EL PASO COUNTY GRADING AND EROSION CONTROL PLAN CHECKLIST

EPC Project Number: TBD PPR-21-023

1 INITIAL GESC PLAN  
 C012

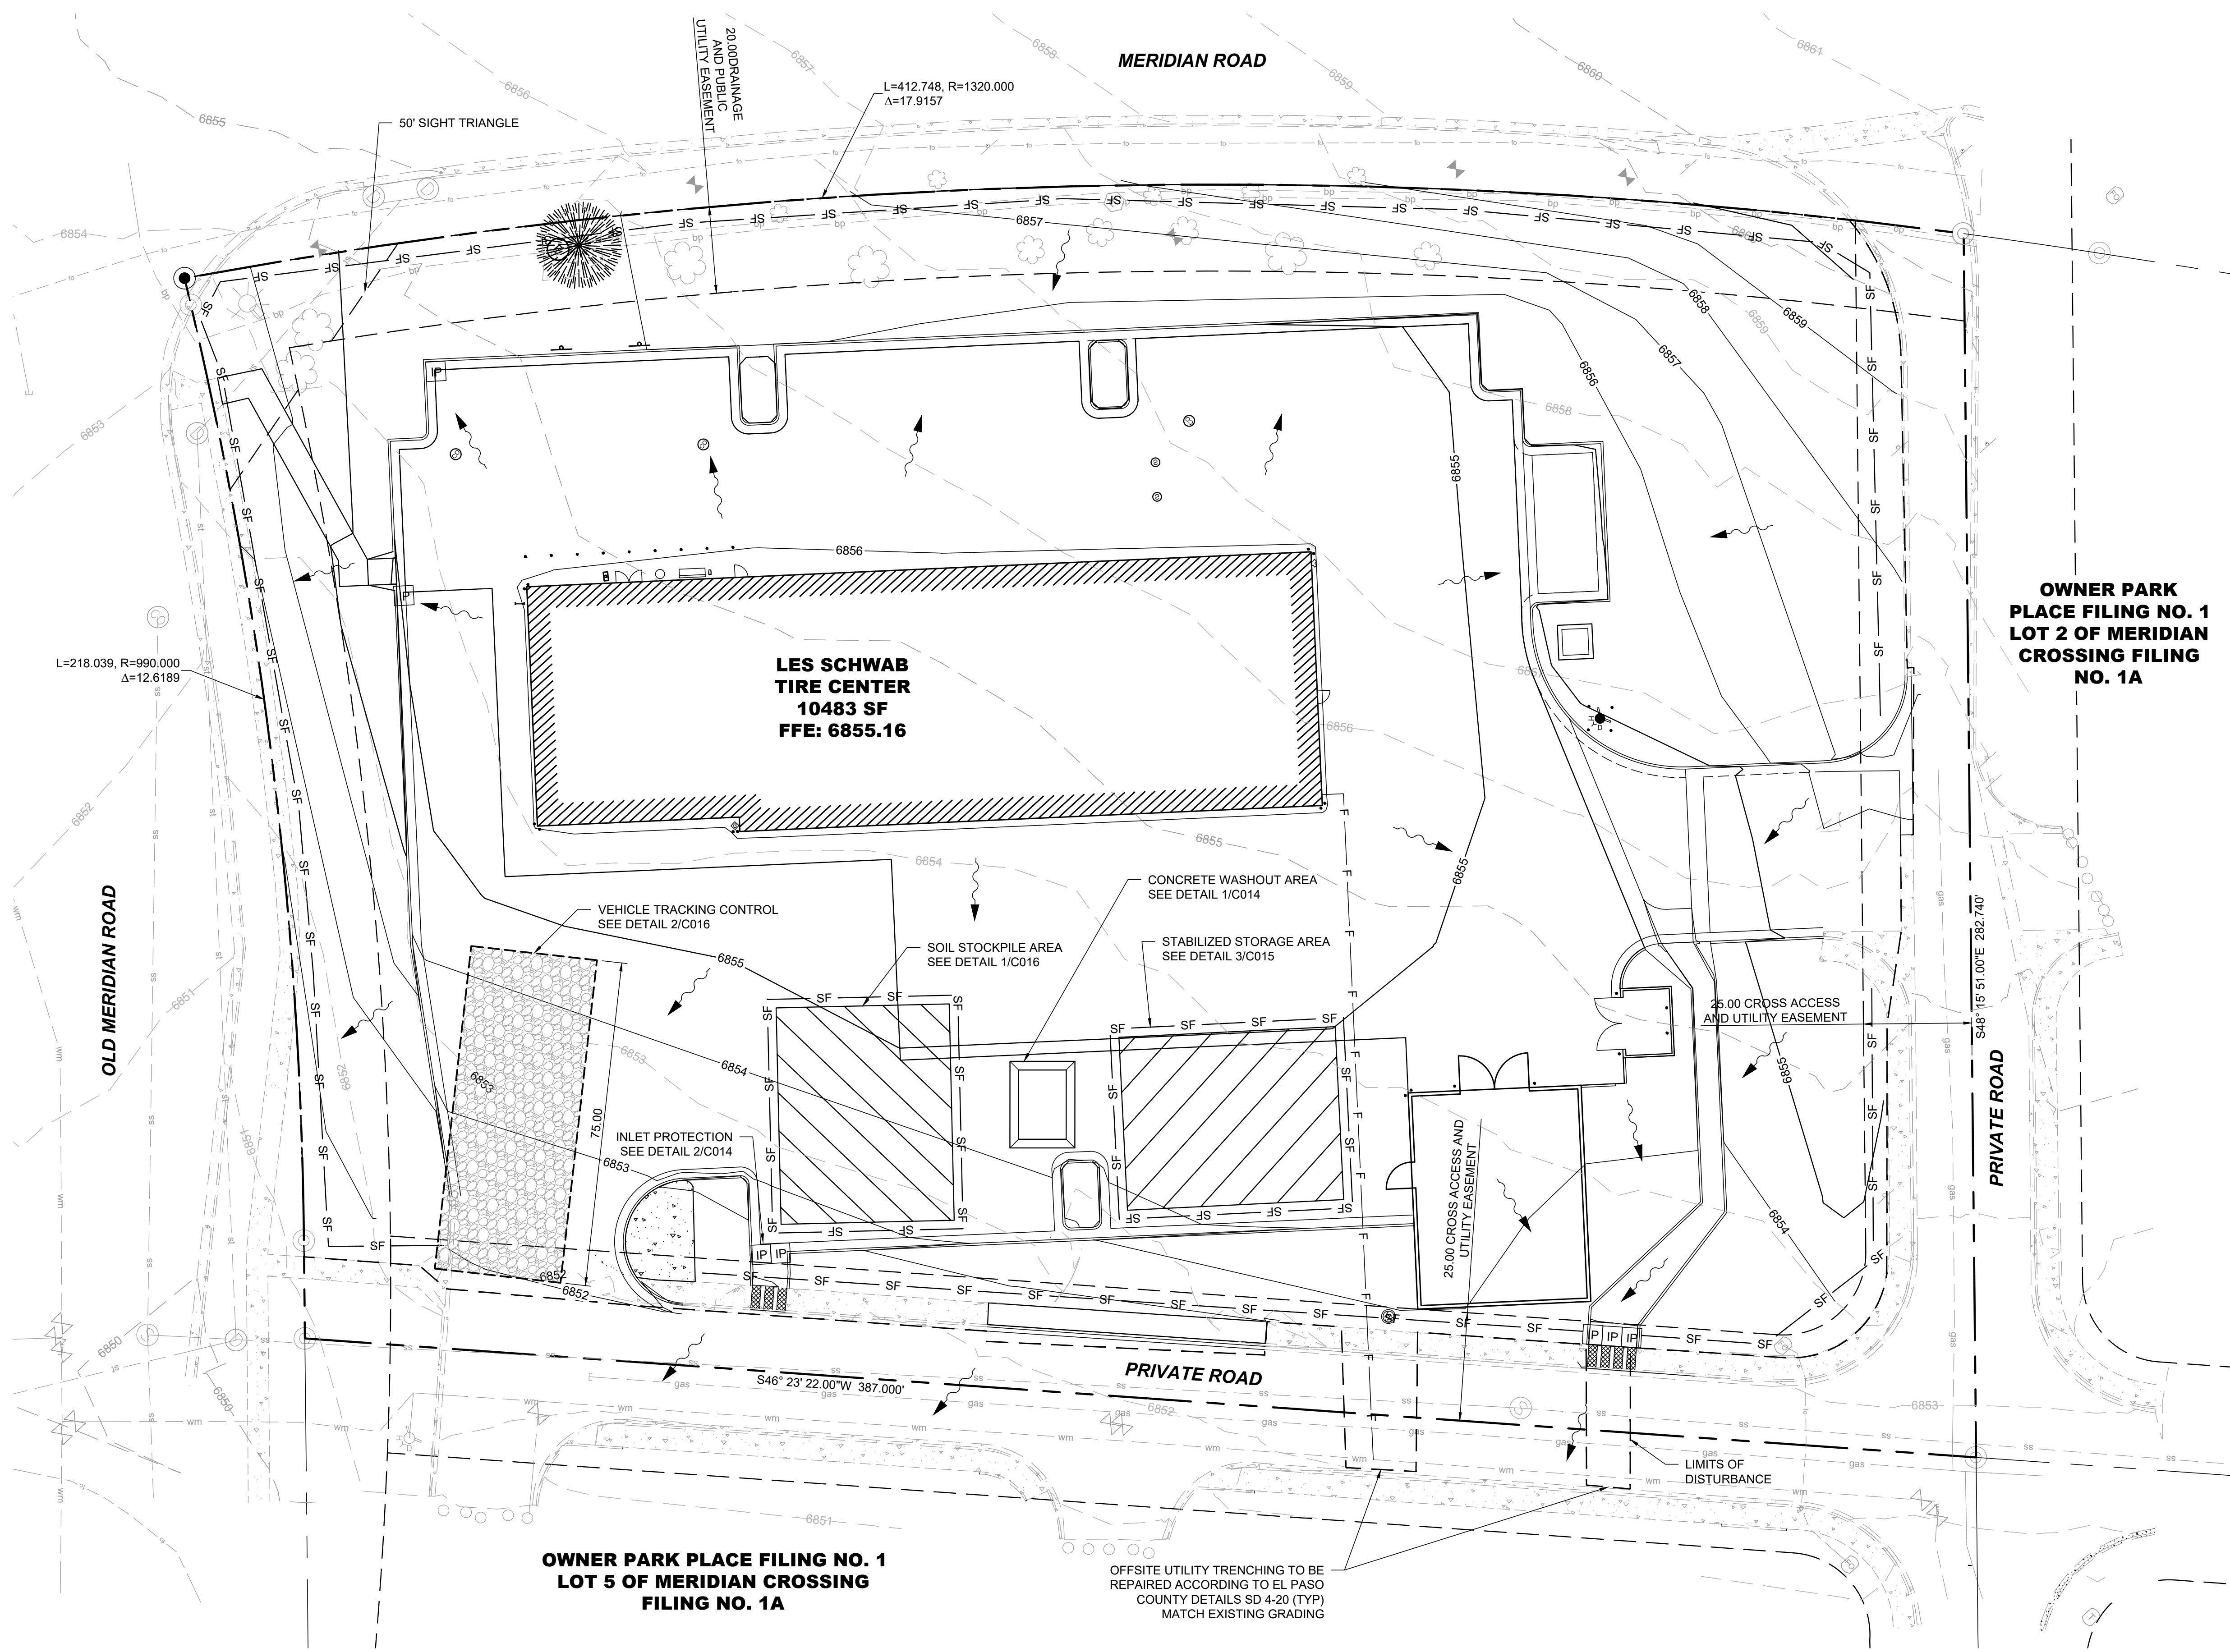
If none will be onsite, revise to "N/A"
